Our Ref: BE/89/19/PL

**Town & Country Planning Act 1990 (as amended)
Town and Country Planning (Development Management Procedure) (England) Order 2015
Application for Planning Permission**

Development The change of use of land for the storage of building materials, equipment & plant & for the parking of 2no. articulated vehicles.

Location Babsham Business Centre Babsham Lane Bersted

BLOCK PLAN - 1:500

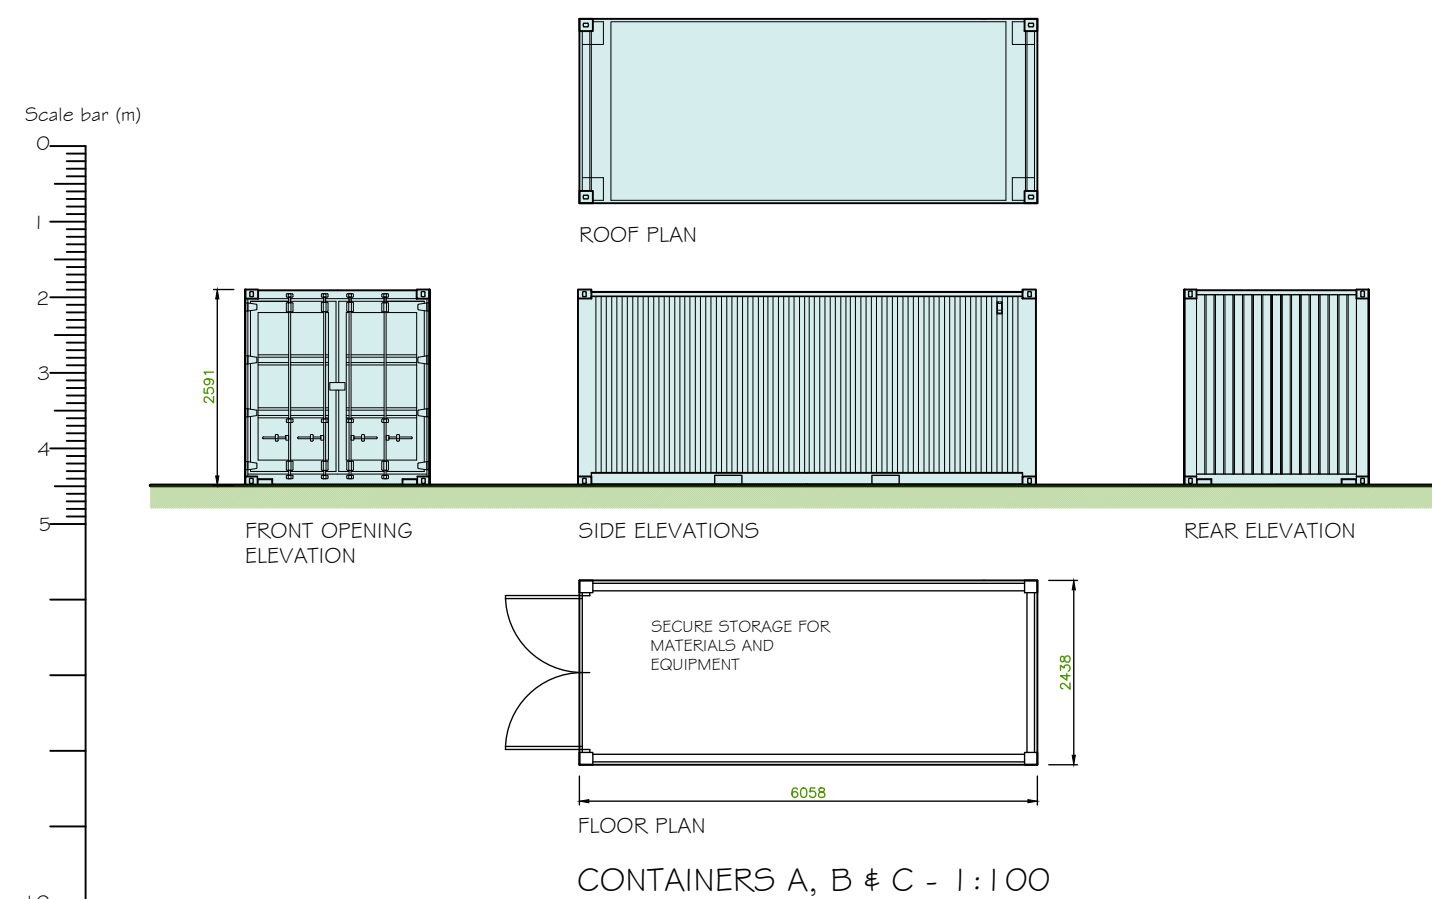
In your statement you refer to an erection of a 2.4m permanent screen fence. If this forms part of the application, please forward amended block plans identifying the position of the fence and provide elevations/details of the screen/fence. Please also confirm what the description should be amended to.
